Addendum

No. 1

Description: Revise front line beverage casework to accept cart. Separate eyewash from handsink per Code review comments.

Project Title Sheetz C-Store
Sawyer Road
Cameron, NC

P111

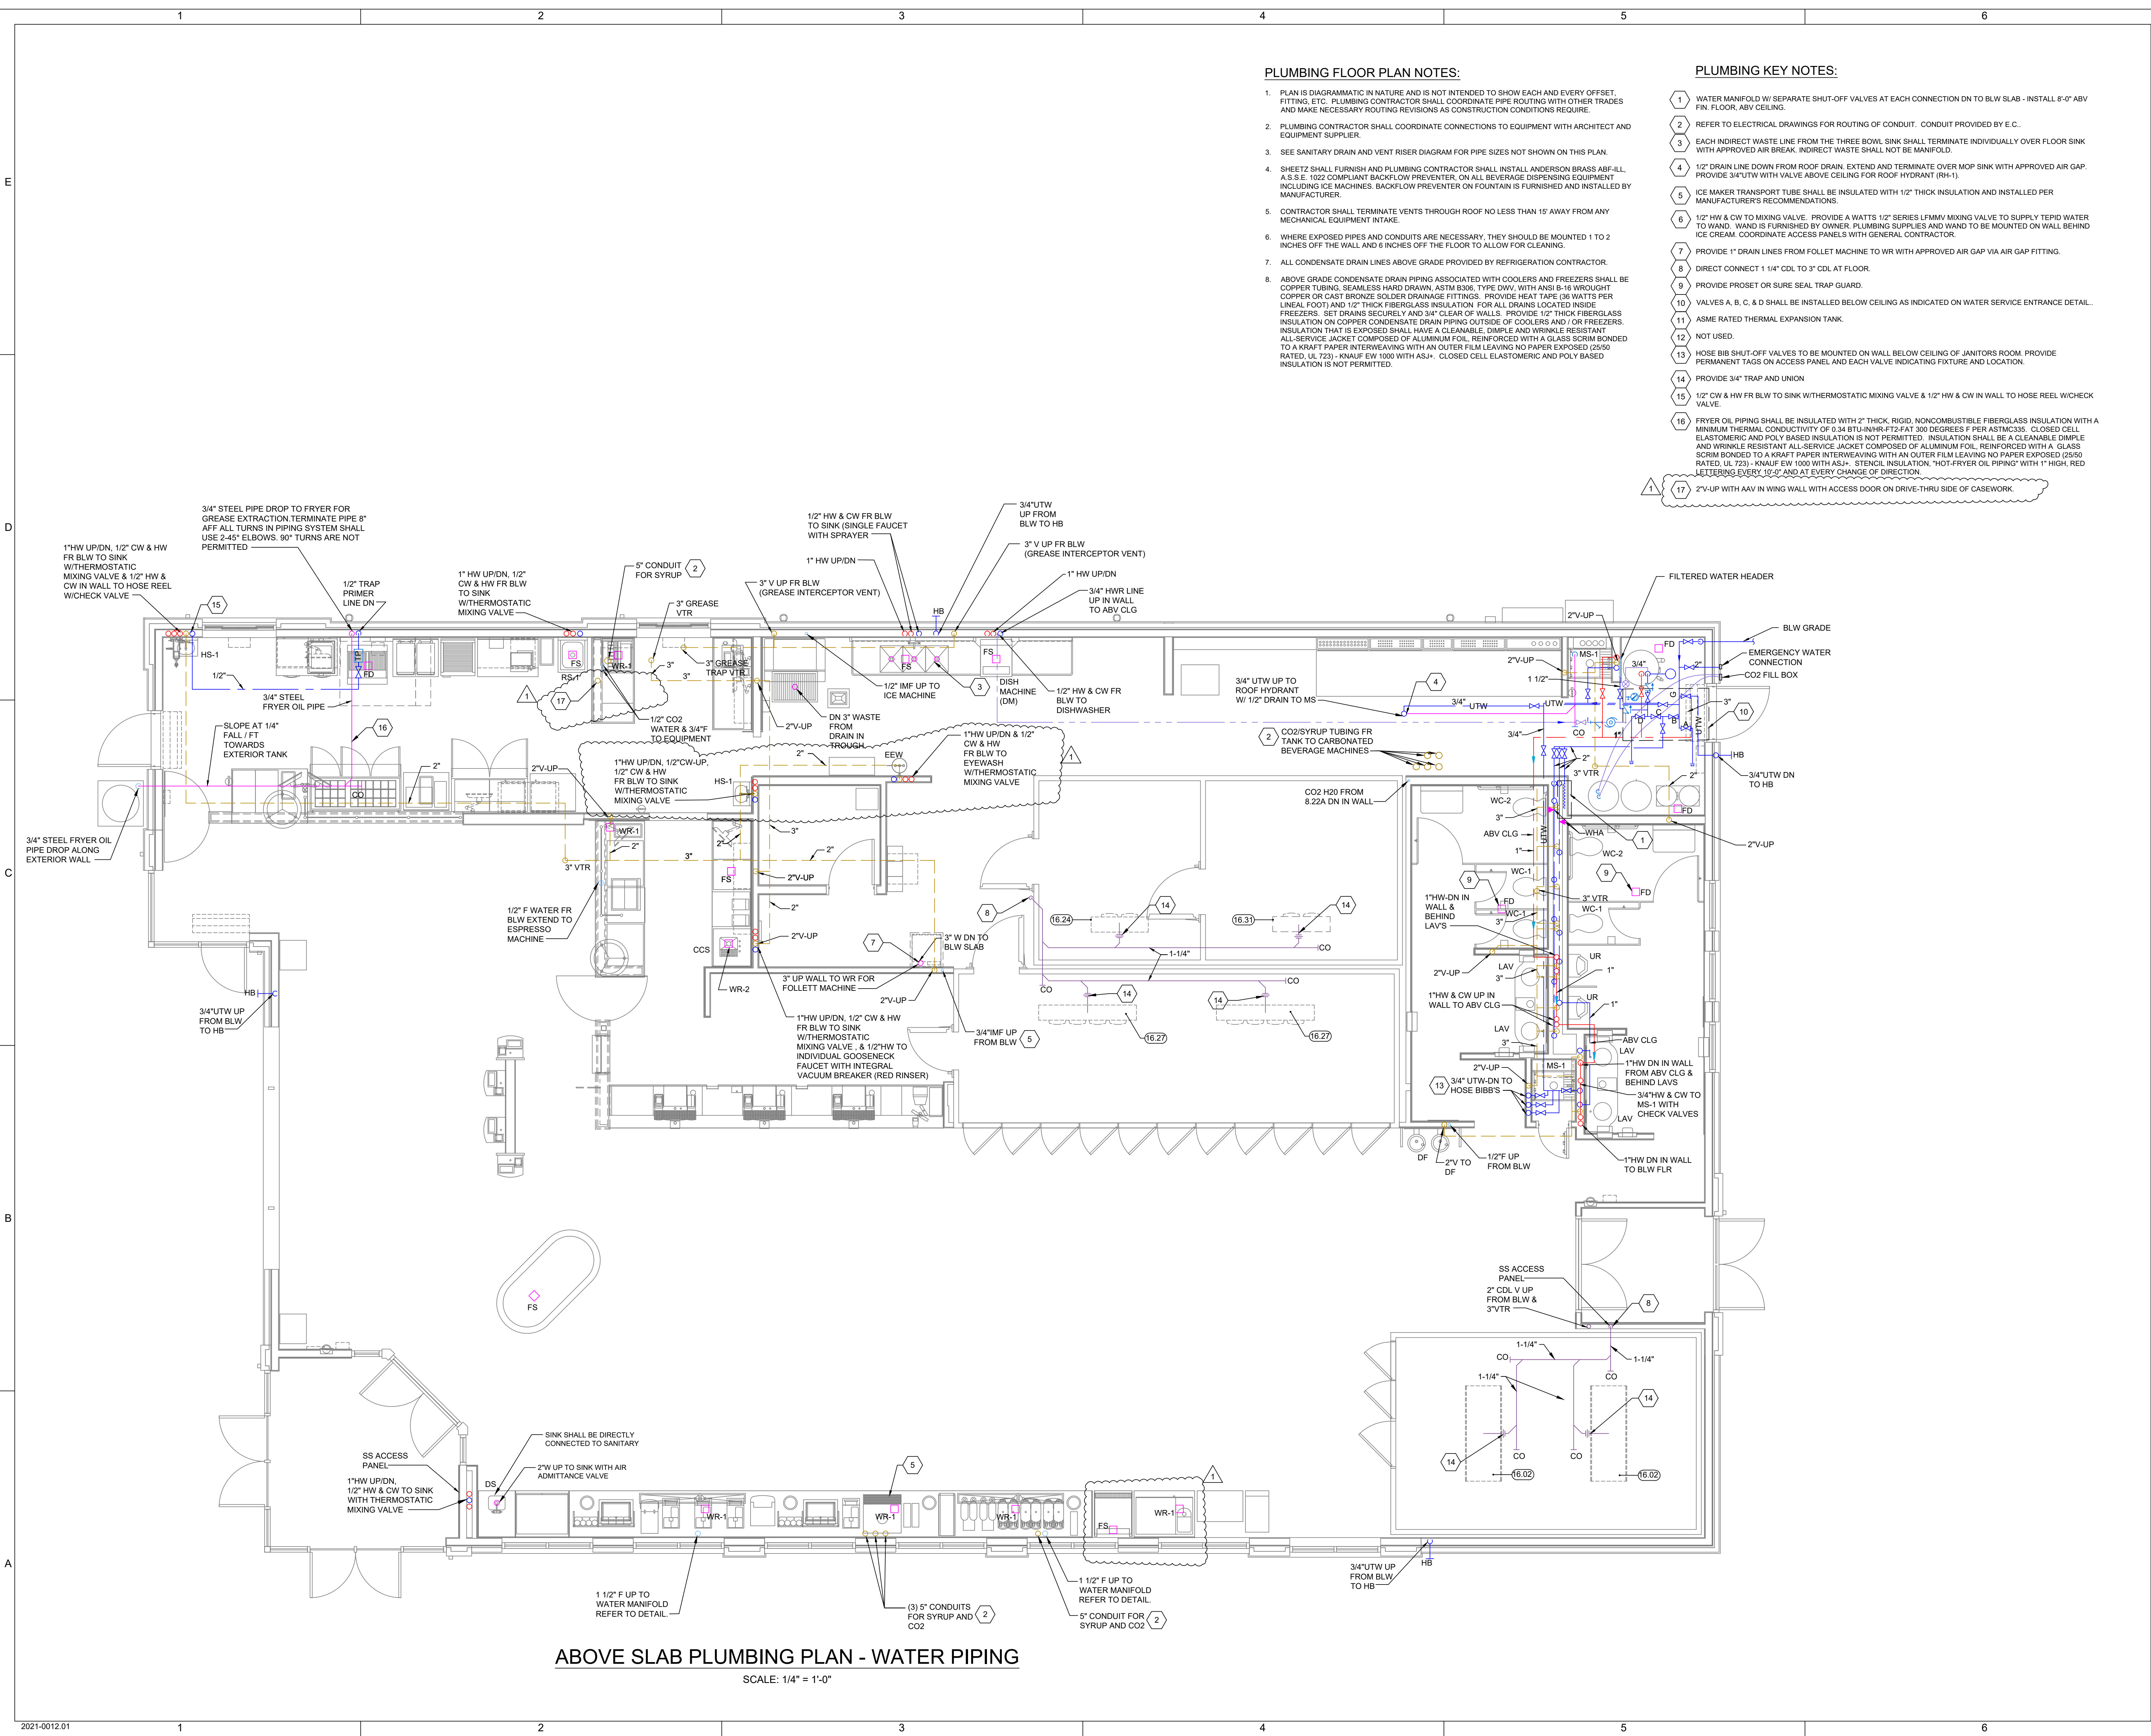
1. RELOCATED drain locations at front line for casework changes.
2. REMOVED 2"V-up note at drive-thru wing wall and replaced with keynote #17.
3. ADDED keynote #17 - 2"W-up with AAV at wing wall with access door on drive-thru side of casework.
4. ADDED eyewash connections and note.
5. REVISED HS-1 sink at kitchen to remove EEW.

1 FOUNTAIN LINE INTERIOR ELEVATION FUB / FOUNTAIN / COFFEE
NTS

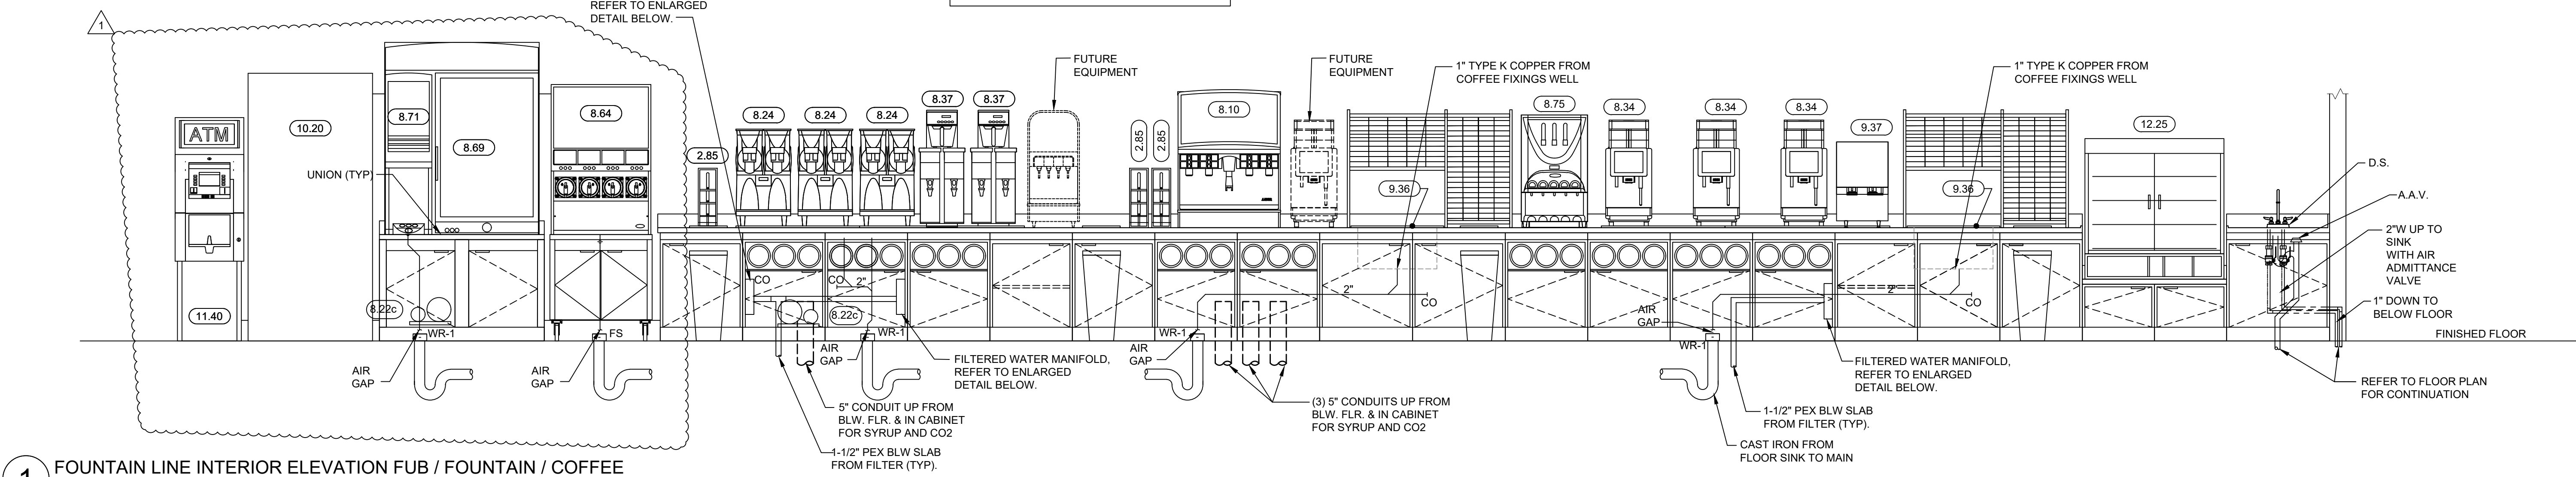
1. REVISED casework and revised drains on Detail #1.

1 WATER PIPING ISOMETRIC
NTS

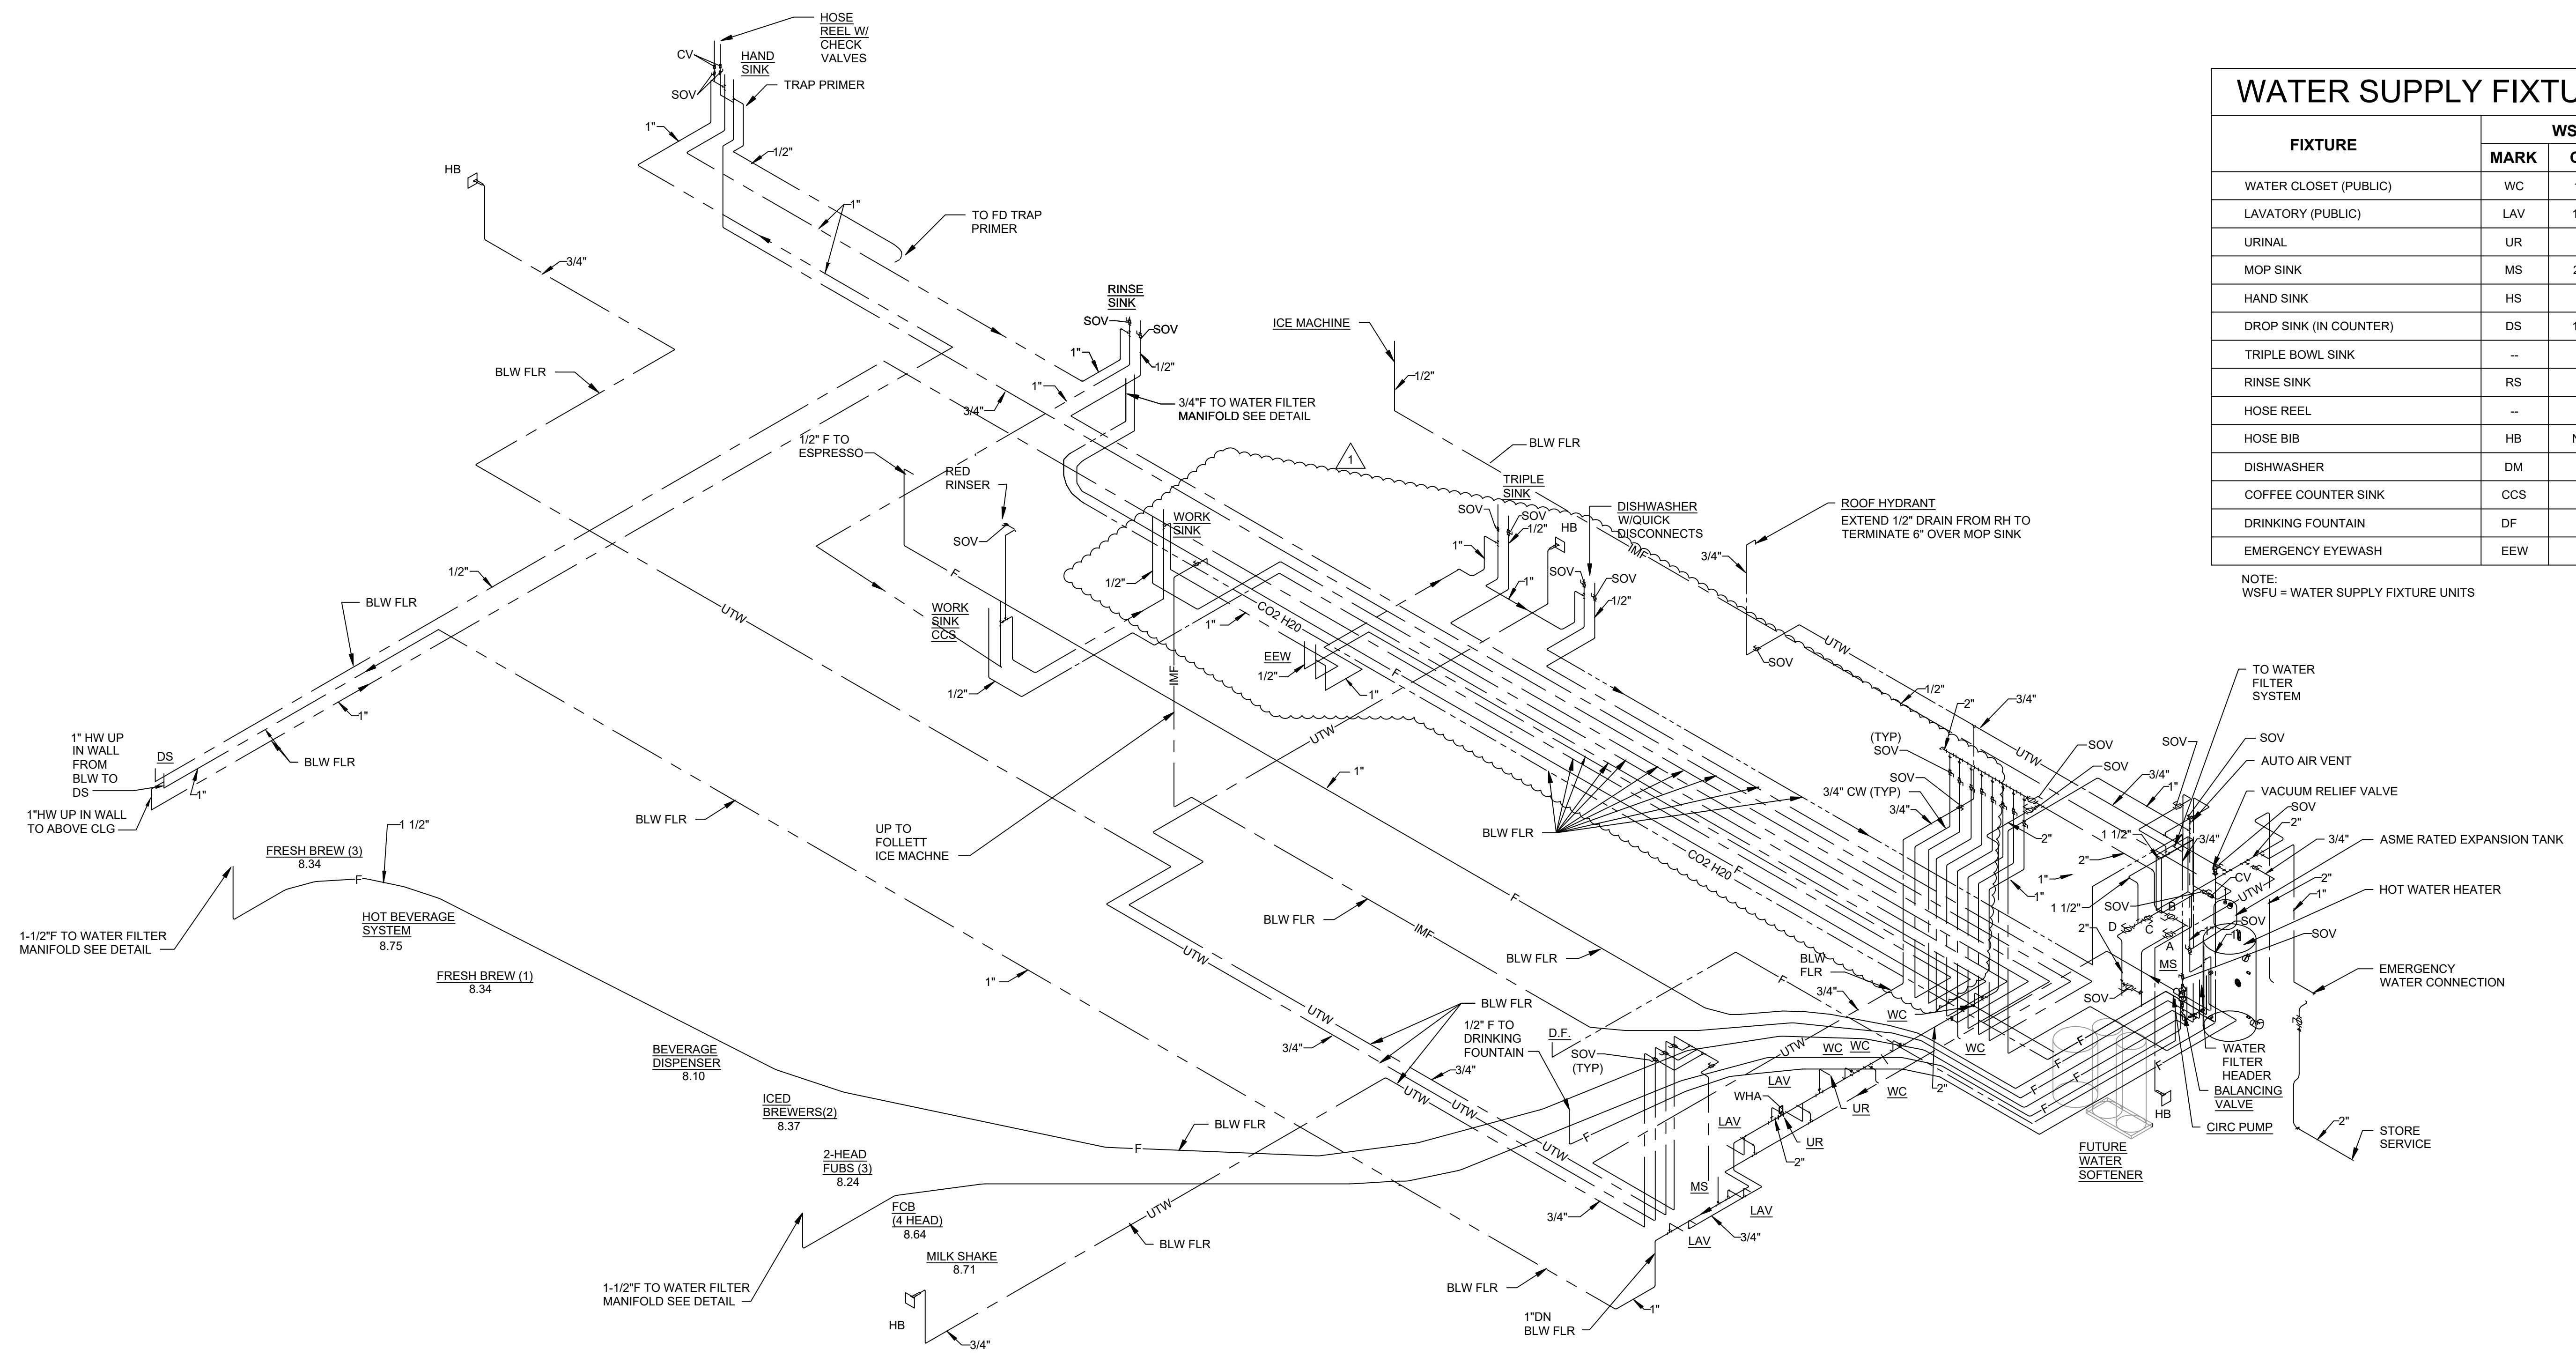
1. REMOVED eyewash connection at work sink.
2. ADDED eyewash and associated piping.
